Consultation Response from KC, Highways Development Management
2020/91337 adj, 1A, Mount Pleasant Lane, Fenay Bridge, Huddersfield, HD8 0AT
Erection of detached dwelling with associated works
Date Responded: 08/09/20 Responding Officer: J Turner Responding Ref: K11-12NW/4

This application seeks approval for the erection of a detached dwelling with associated works at Mount Pleasant Lane, Fenay Bridge.

PROPOSED BLOCK PLAN
1:500

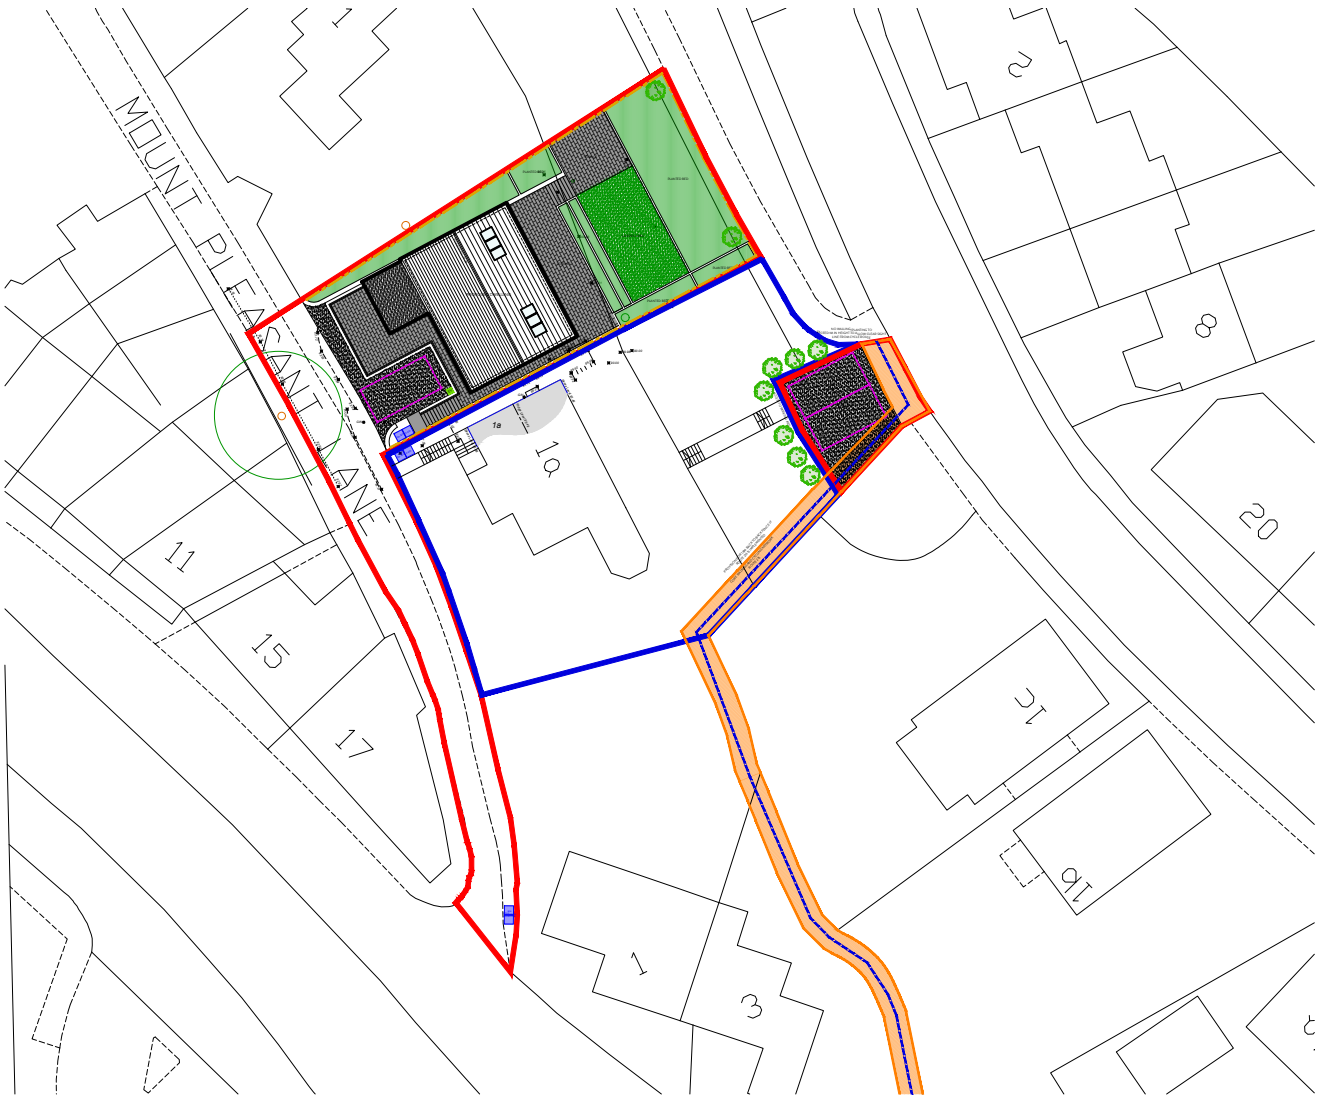
The proposed dwelling would consist of five bedrooms, and would benefit from three off-street parking spaces in the form of a double garage and a single hard standing. The building would remove the current parking spaces for 1a Mount Pleasant Lane, and the intention is to provide two spaces for this dwelling accessed from Fenay Bridge Road. As such, the proposal is unlikely to significantly intensify the use of Mount Pleasant Lane, with the cars that presently park there being displaced to the access served from Fenay Bridge Road.

Prior to the development being brought into use, the approved vehicle parking areas shall be surfaced and drained in accordance with the Communities and Local Government; and Environment Agencies 'Guidance on the permeable surfacing of front gardens (parking areas)' published 13th May 2009 (ISBN 9781409804864) as amended or superseded; and thereafter retained throughout the lifetime of the development.

Before development commences, details of suitable storage, bin presentation points and access for collection of wastes from the dwellings hereby approved shall be submitted to and approved in writing by the Local Planning Authority. The approved details shall be provided before first occupation and shall be so retained thereafter.
